**RE: Summary report on condition of the existing façade walls**

After the appointment dated 2<sup>nd</sup> of November 2023 for the Eagle Works project, Great Brickkiln St, WV3 0PW, Engineeria was asked to develop the structural design which was initially carried out by the previous structural engineer.

Drawing Title
**Demolition Elevations
North & West**

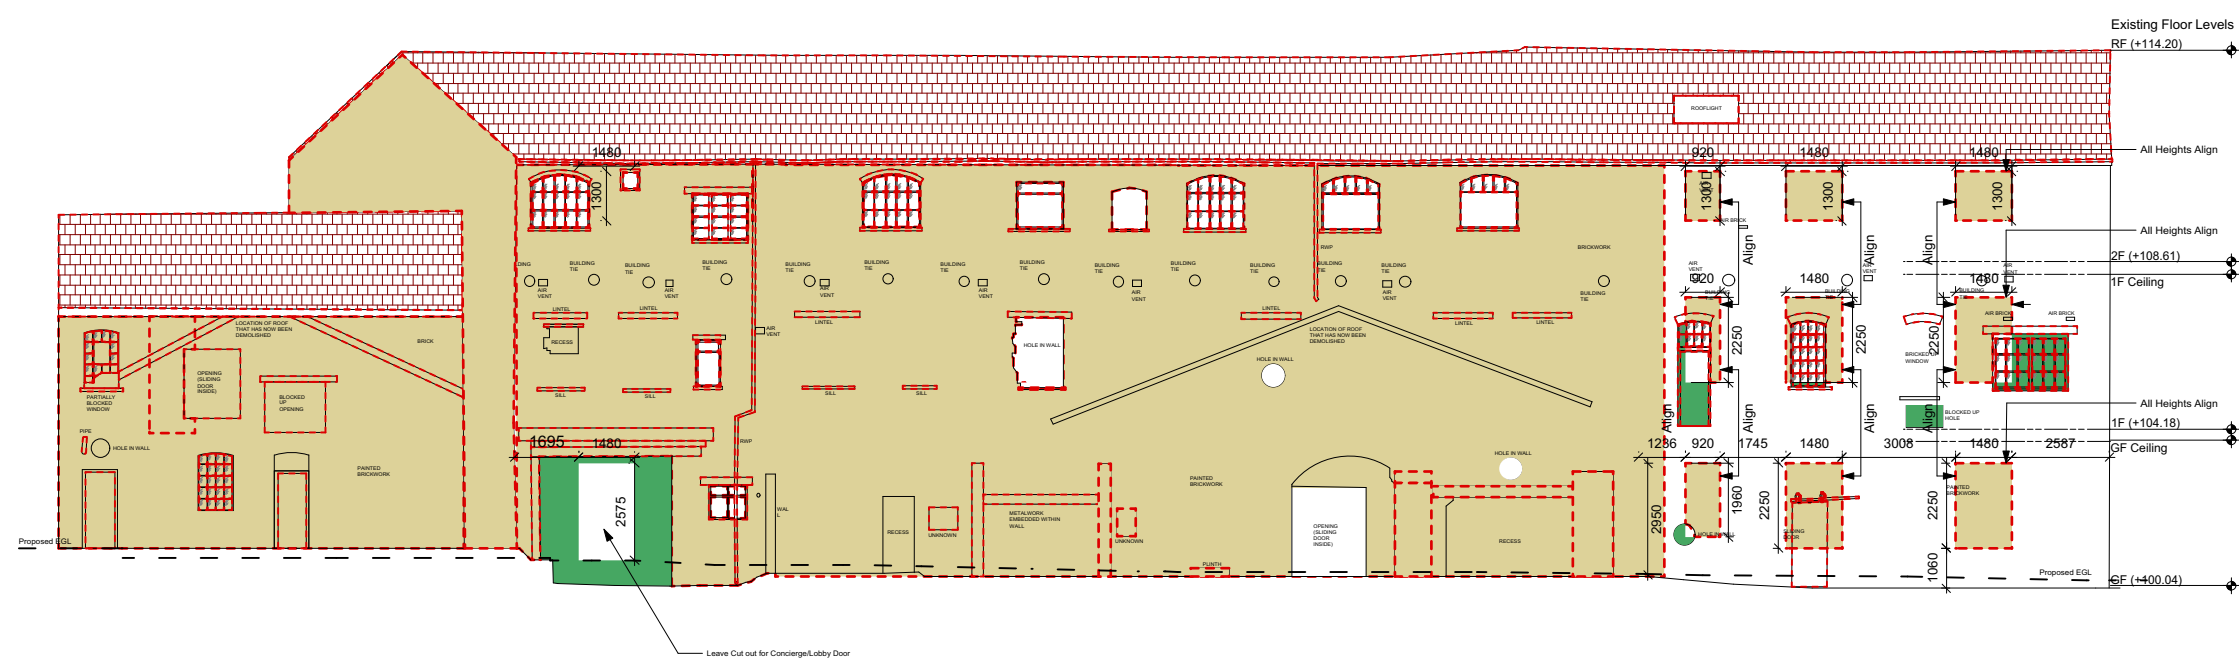
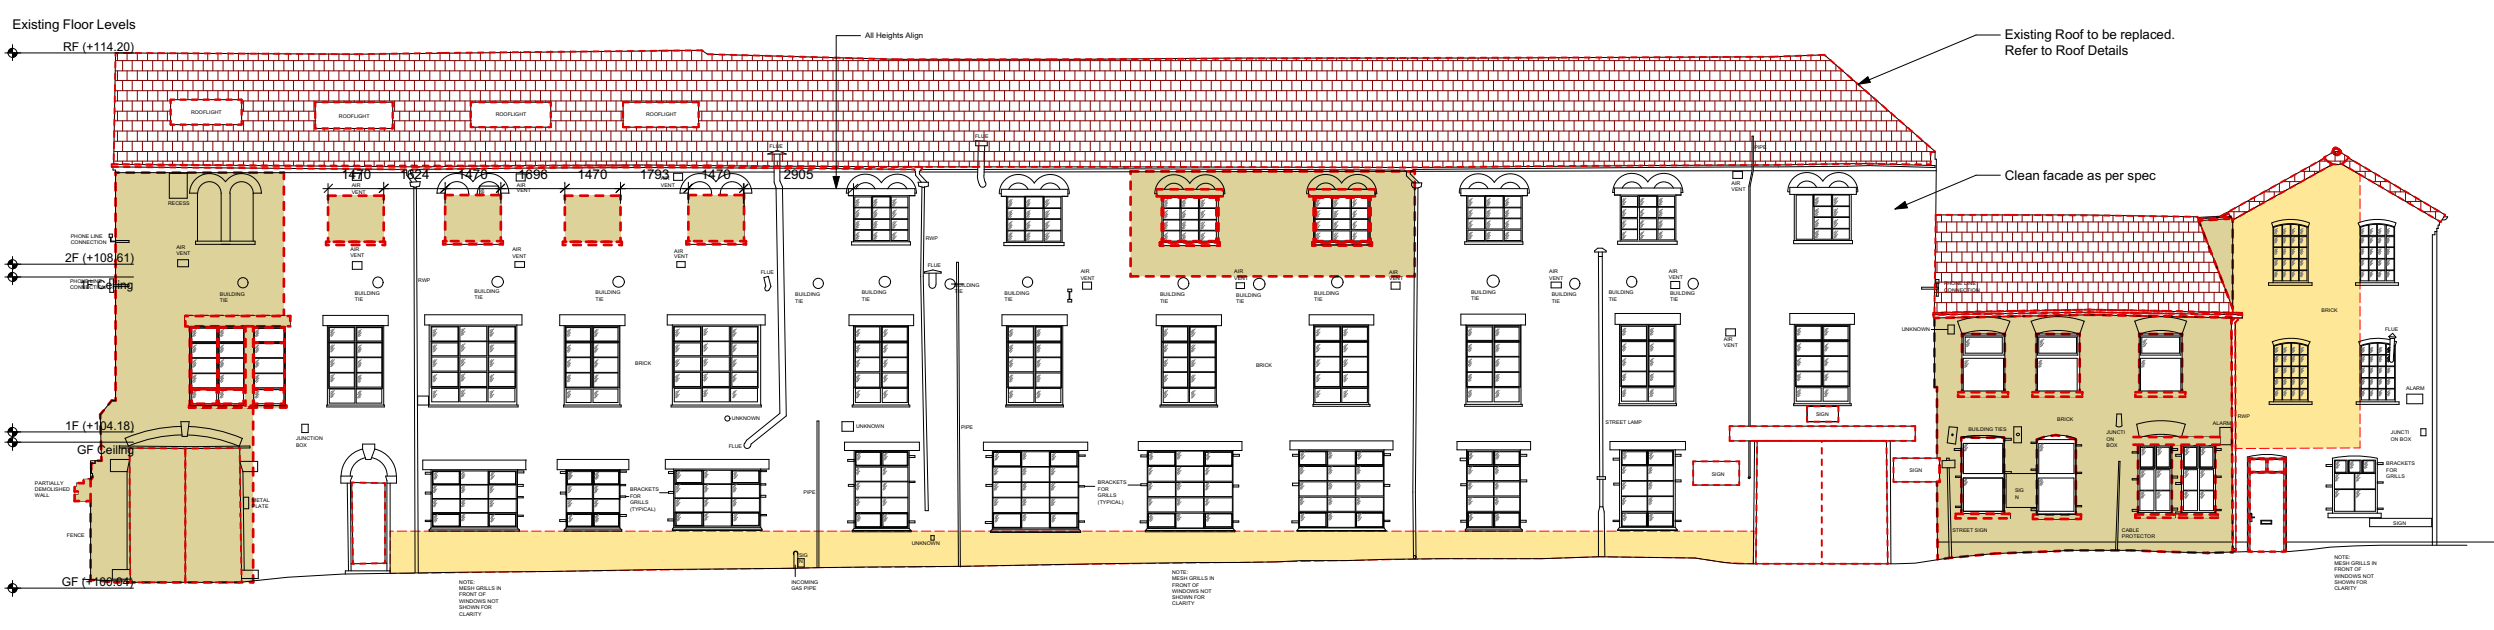
- Demolition and reconstruction of some areas of the existing external masonry walls, indicated in red and orange in the attached drawing,
- Repair and strengthening of some areas of the existing external masonry wall, indicated in yellow in the attached sketch.

Verticality Survey

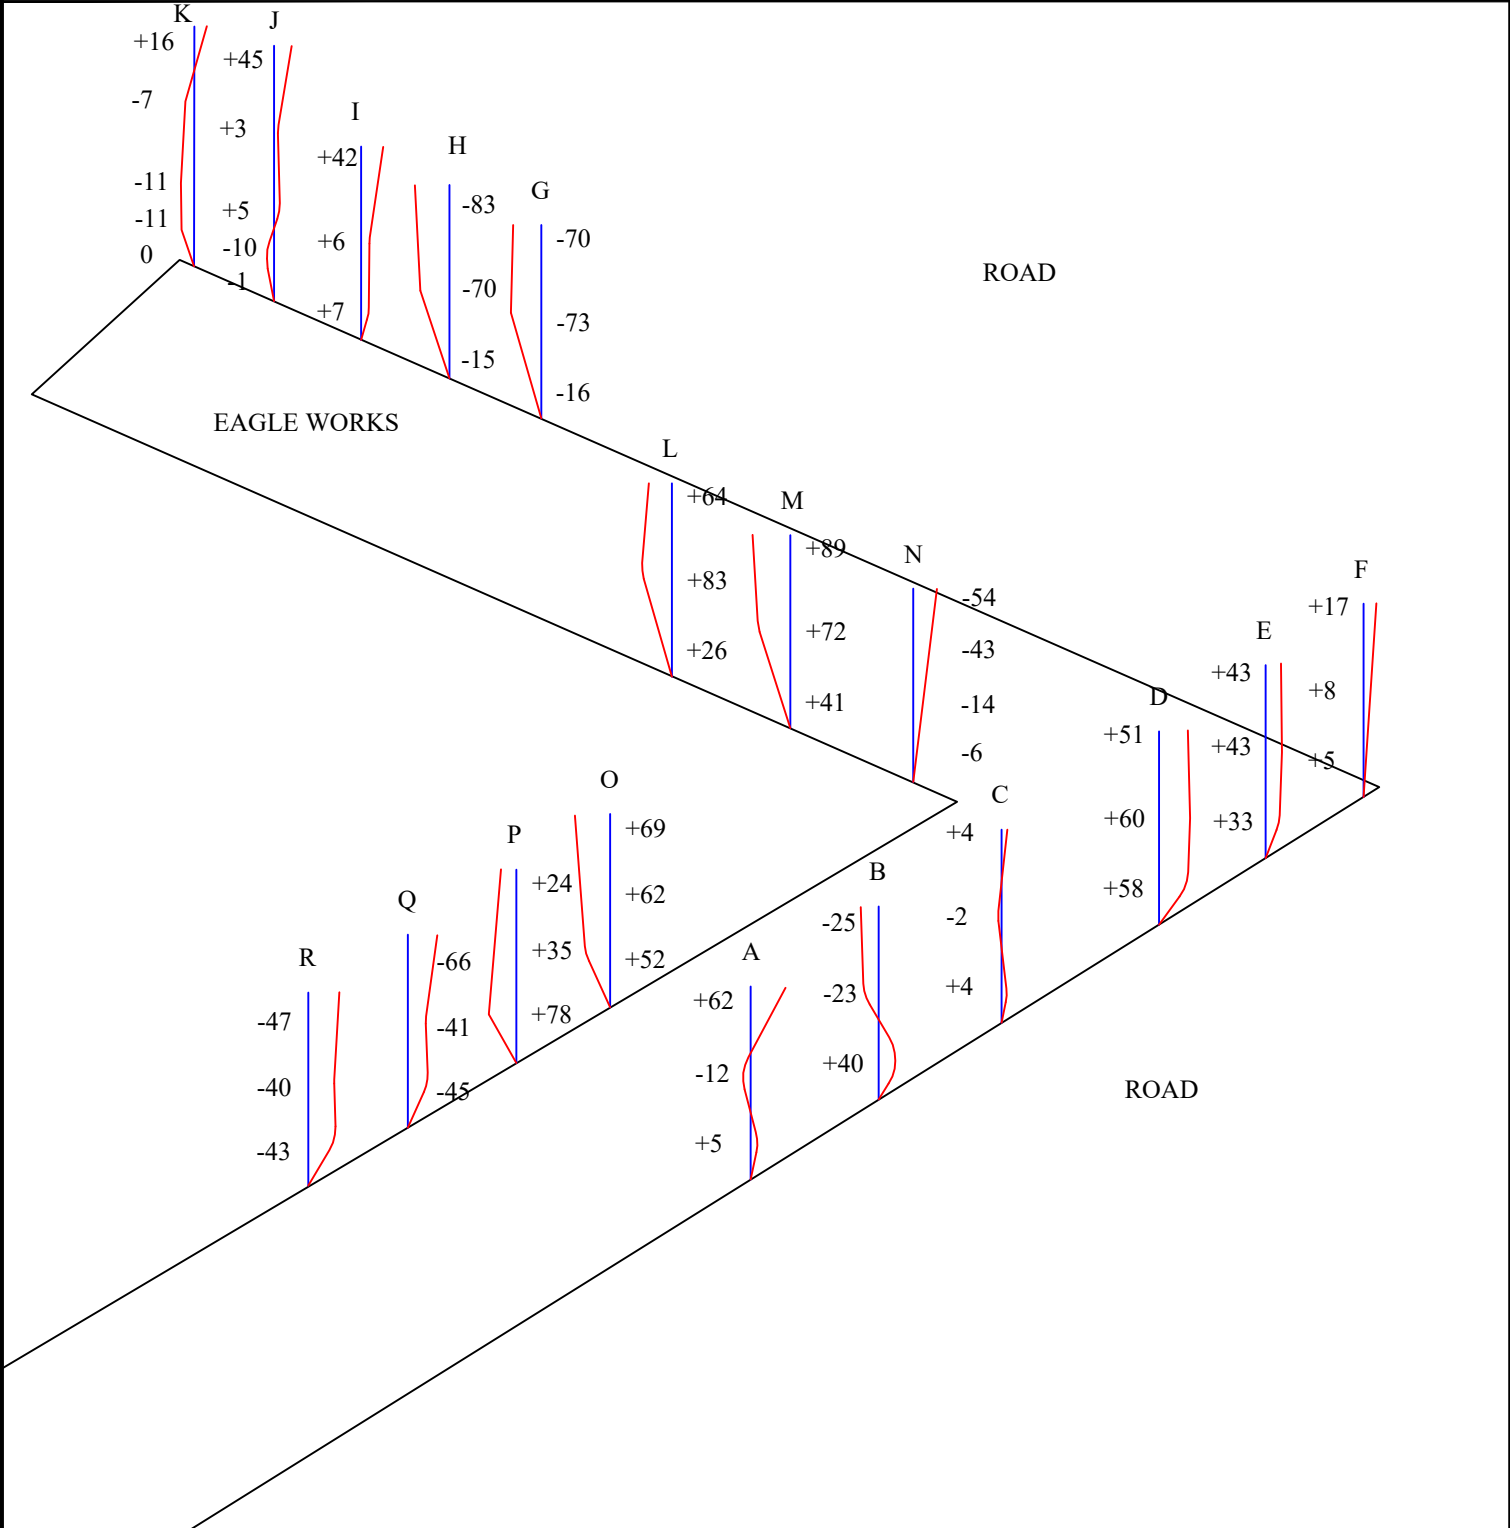
After receiving the survey results and cross-checking them for accuracy (survey information received on: 19<sup>th</sup> of December 2023 (wall survey part 1), 22<sup>nd</sup> of December 2023 (wall survey part 2), 22<sup>nd</sup> of January 2024 (Wall survey cross check), 1<sup>st</sup> of February 2024 and 6<sup>th</sup> of February 2024 (final survey)), it was evident that the lack of verticality of some portions of the existing external walls was not within the limits of structural safety.

In conclusion, the survey of the existing façade walls revealed a lack of verticality in some areas that must be addressed immediately as a matter of structural and public safety.
